CITY OF ALBUQUERQUE

August 10, 2023

Re: The George/ 34 Unit Apartment Building
1701 Central Ave. NW
Traffic Circulation Layout
Architect's Stamp 08-04-23 (J13-D220)

TCL01

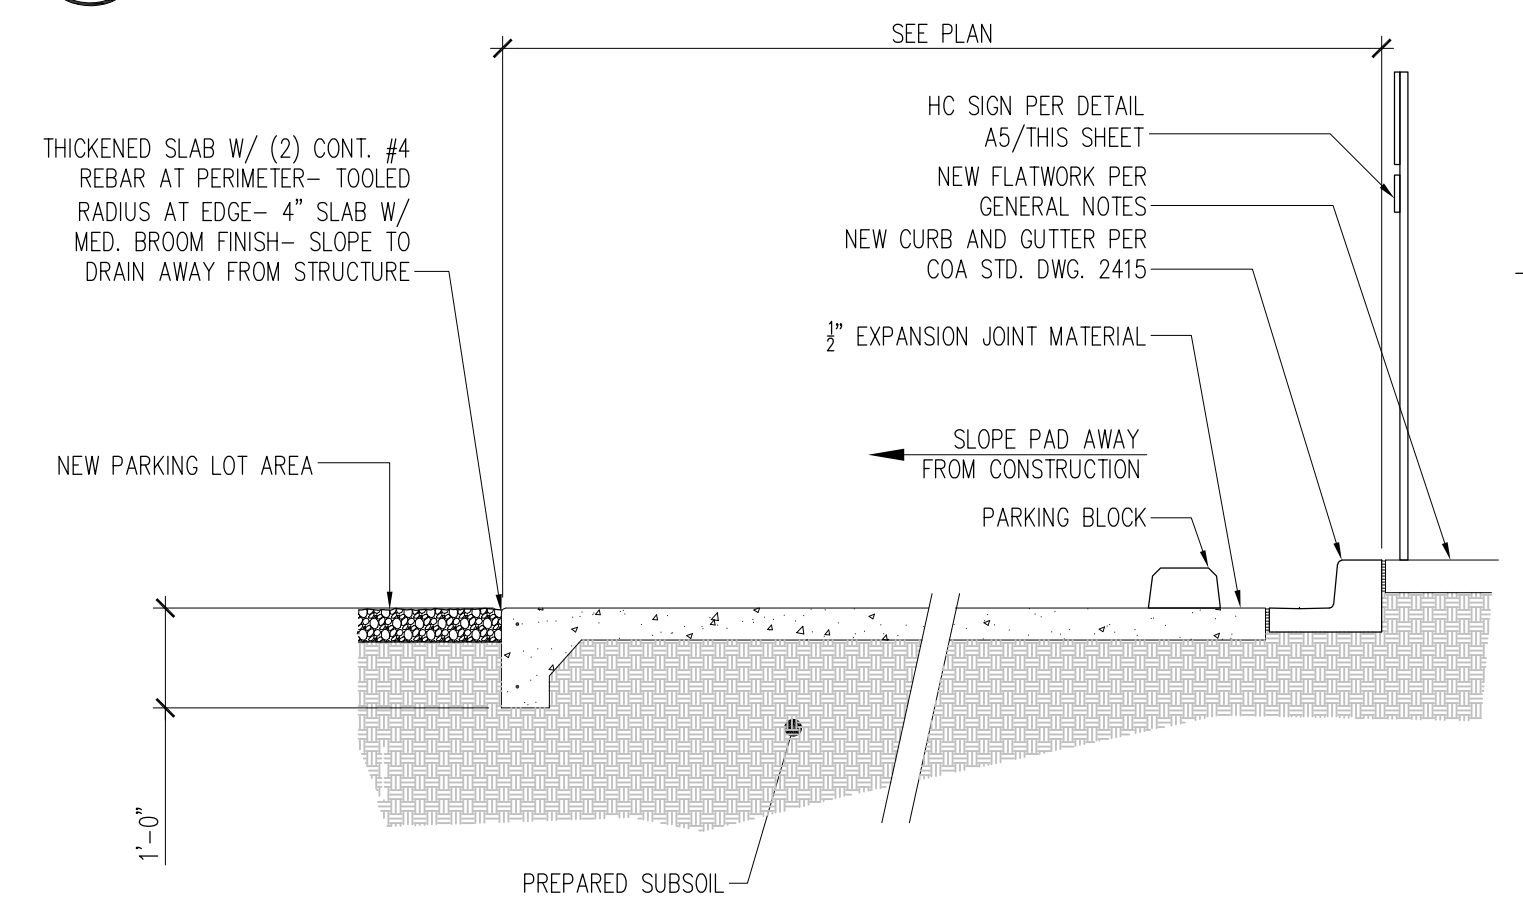
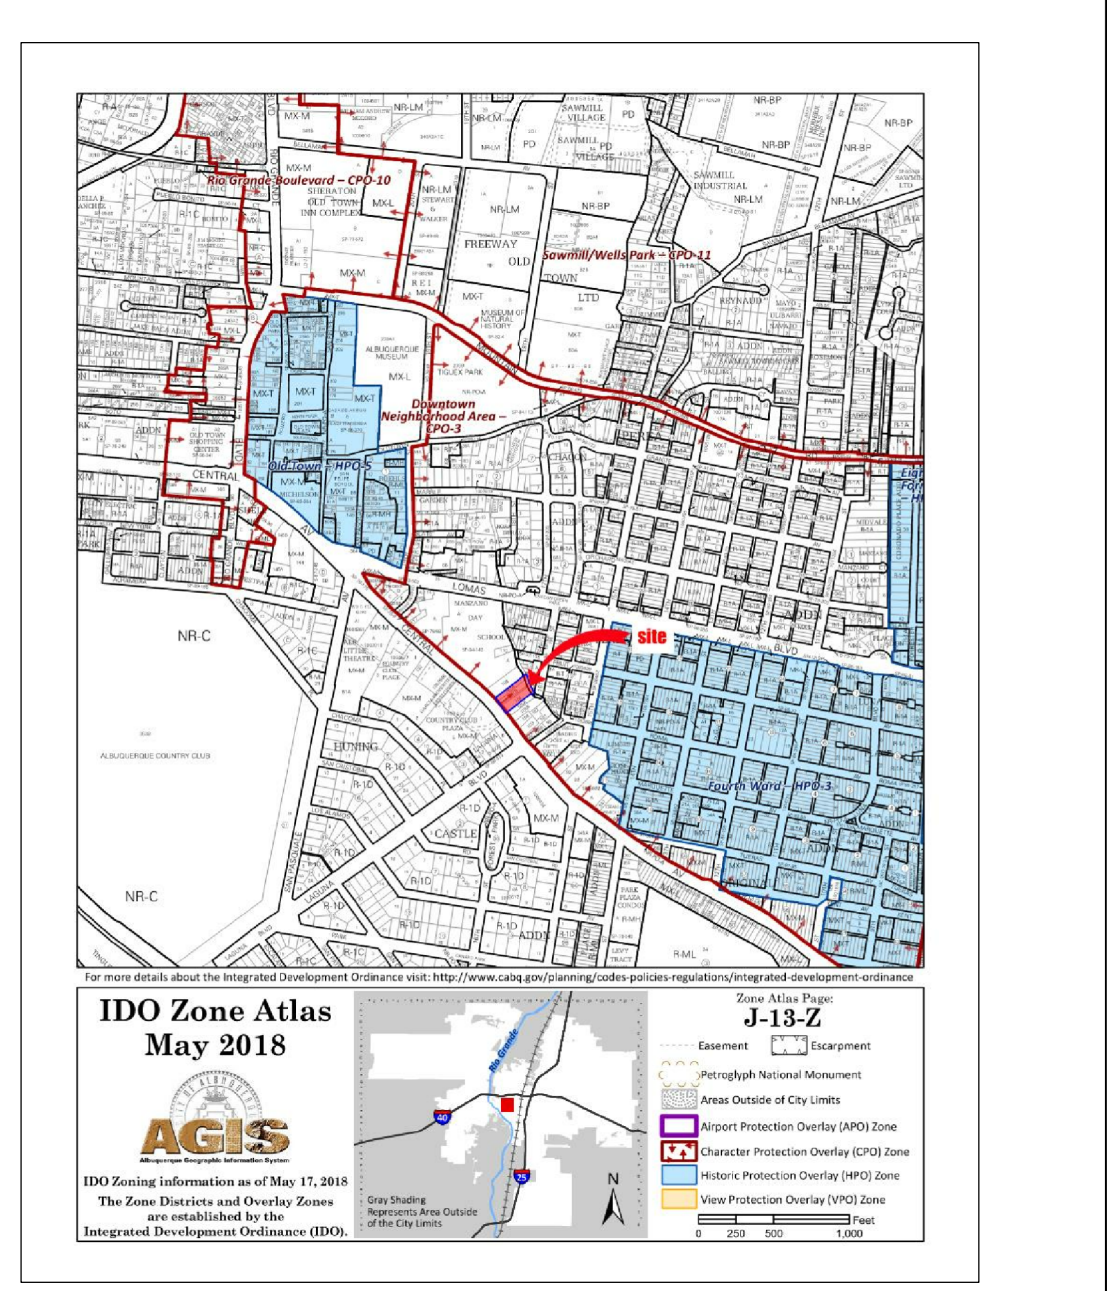
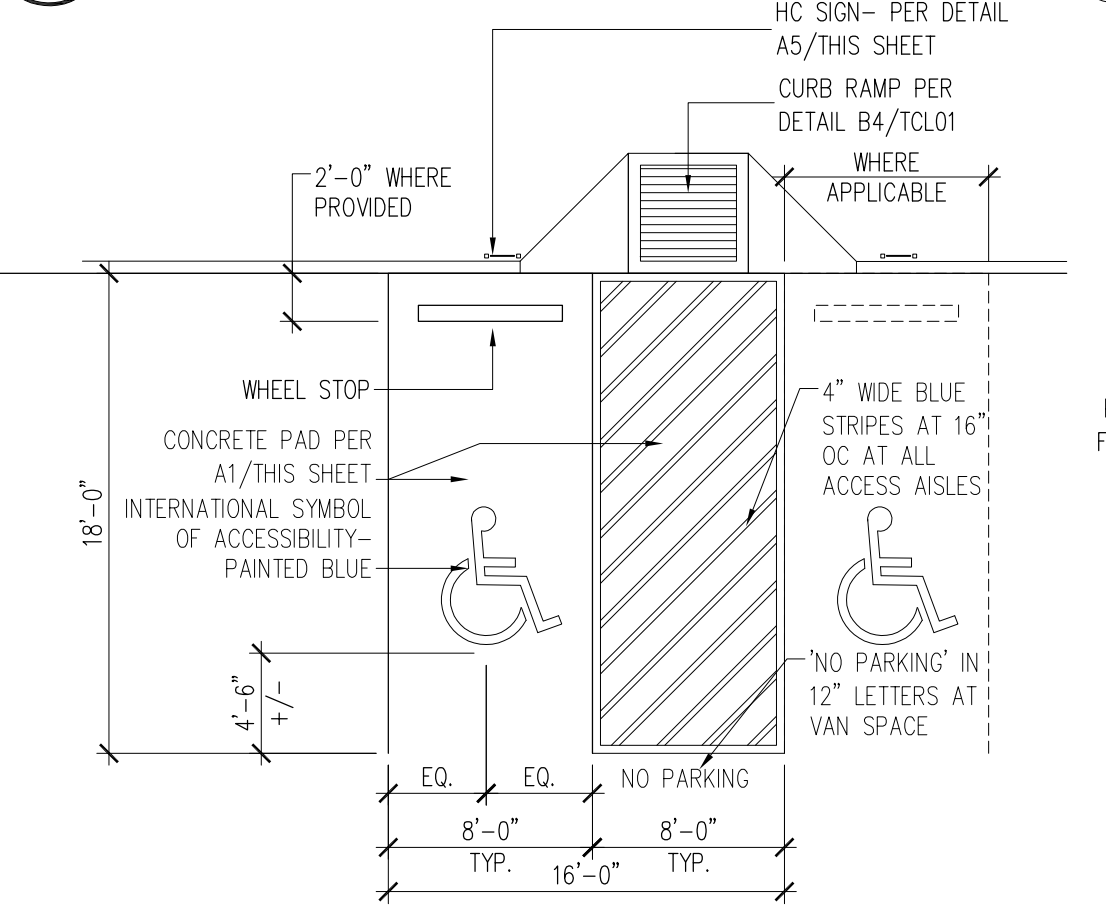
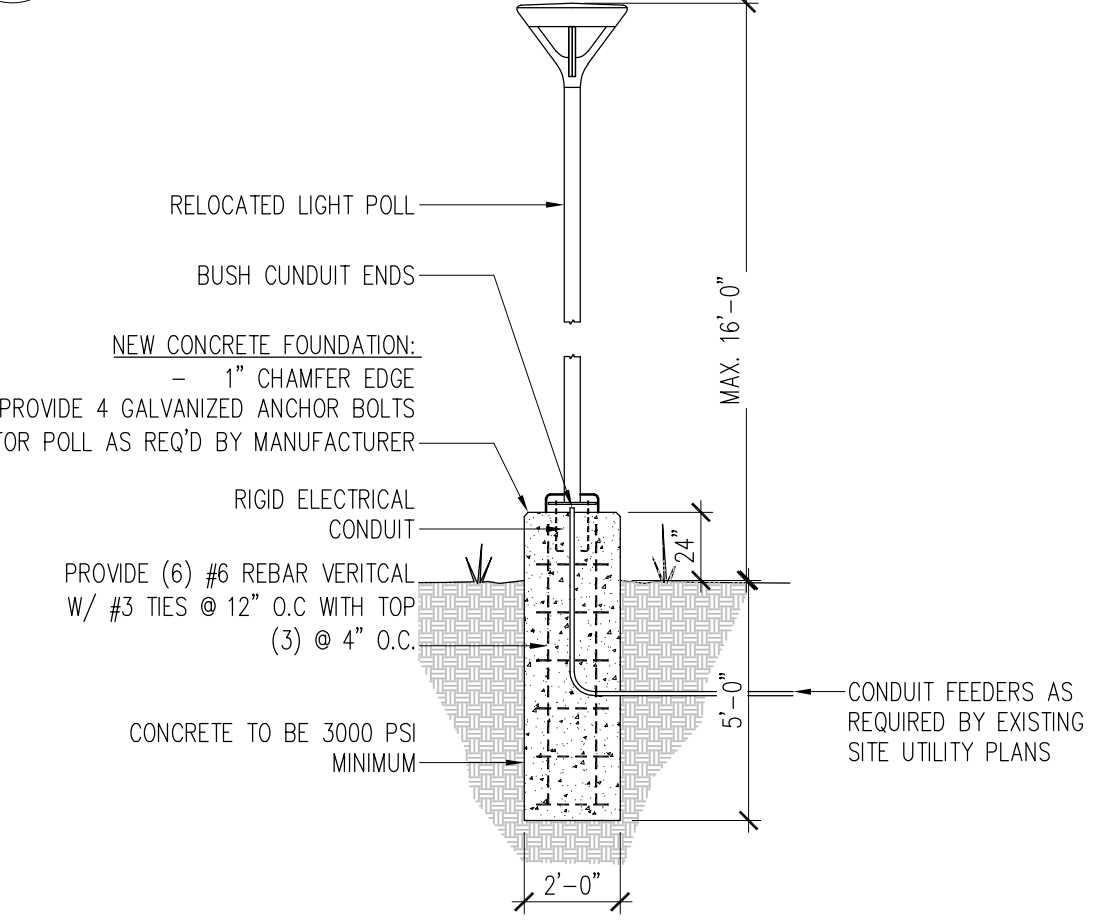
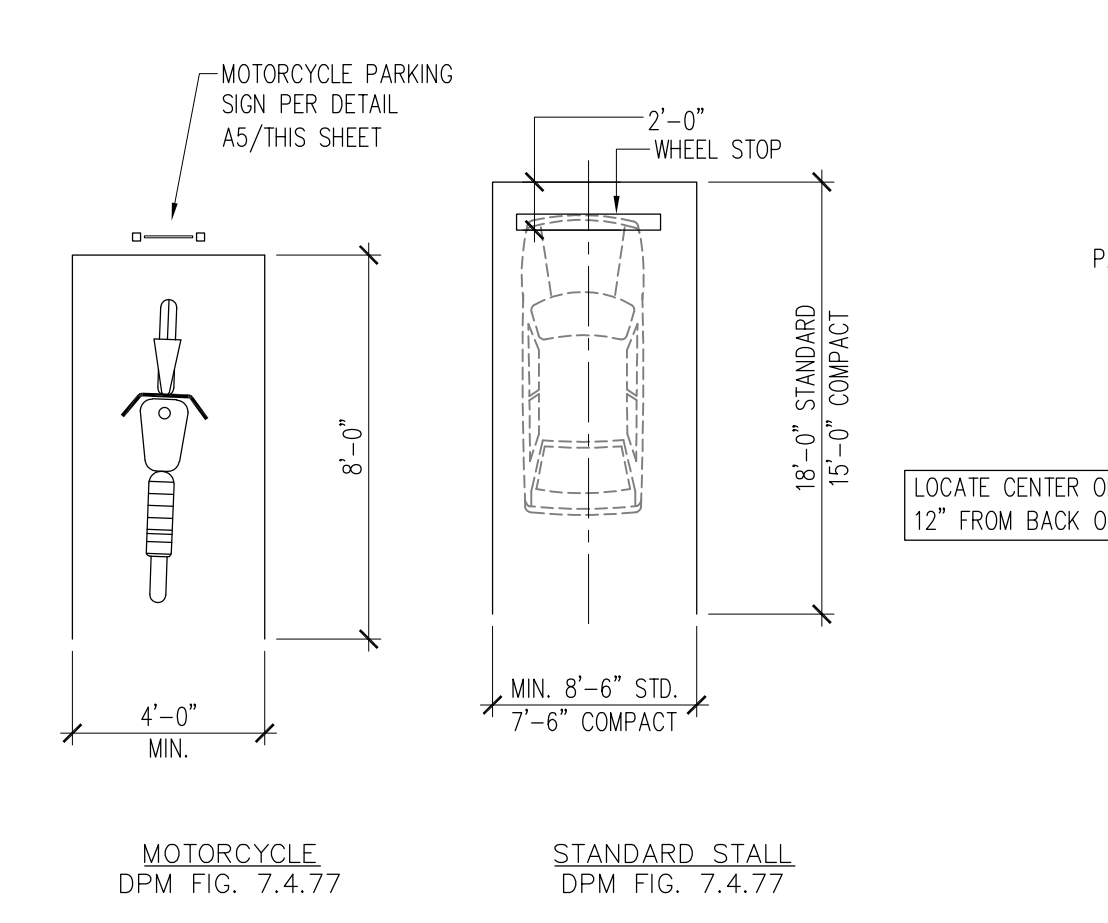
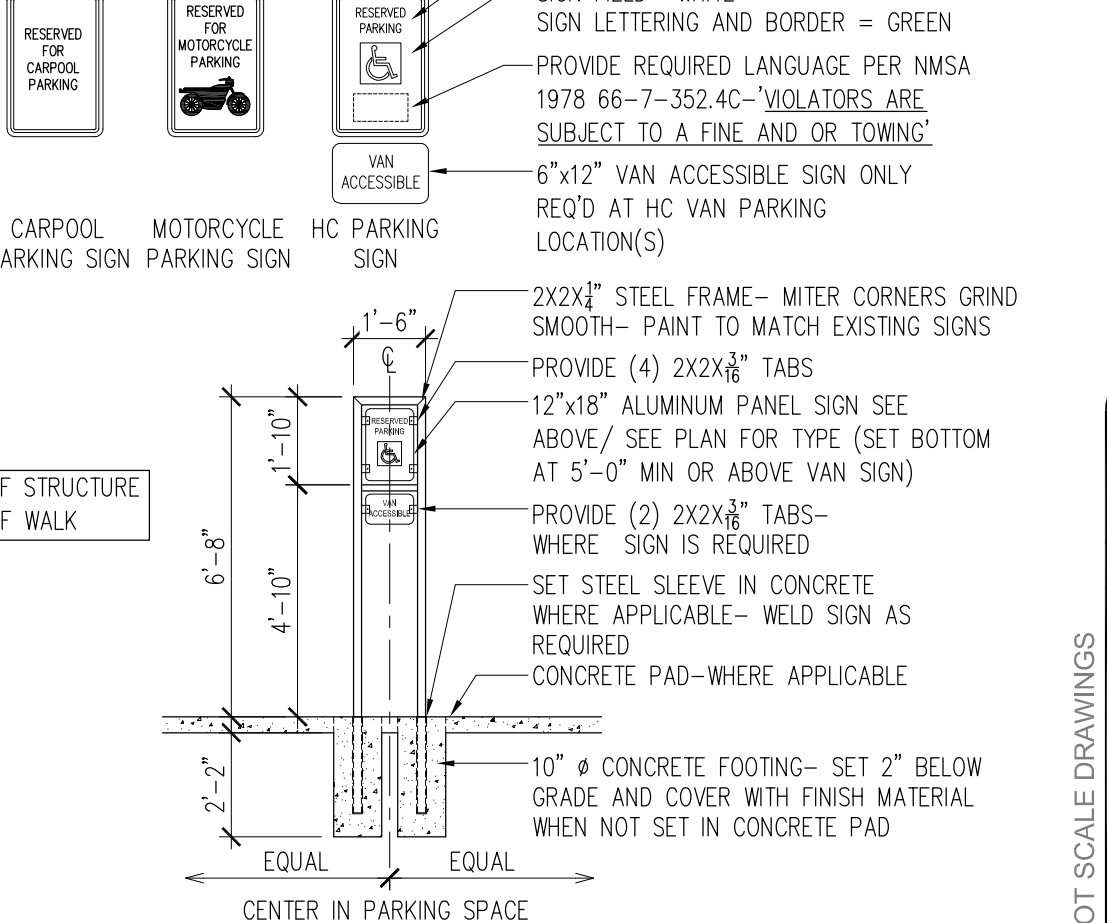
1. Please show on the site plan the north direction to determine the orientation of the site.
2. Identify all existing access easements and rights of way width dimensions.
3. Identify the right of way width, medians, curb cuts, and street widths on Central Ave. and 16th St.
4. Shared parking agreement must approve and signed by director Alan Varela and city authorized notary.
5. Site access must be built per City standard.
6. Keynote 18: please reference COA STD DWG 2430. And it appears there is a water meter on the public sidewalk by the construction area off Central. Please contact Water Authority for a permit.

7. Please define keynote 29.
8. Refuse vehicle maneuvering shall be contained on-site. The refuse vehicle shall not back into the public right of way.; provide a copy of refuse approval.
9. Show the clear sight triangle and add the following note to the plan: "Landscaping and signage will not interfere with clear sight requirements. Therefore, signs, walls, trees, and shrubbery between 3 and 8 feet tall (as measured from the gutter pan) will not be acceptable in the clear sight triangle.
10. Please specify the City Standard Drawing Number when applicable.
11. Add a note stating "All broken or cracked sidewalk must be replaced with sidewalk and curb & gutter." A build note must be provided referring to the appropriate City Standard drawing.
12. Please provide a letter of response for all comments given.
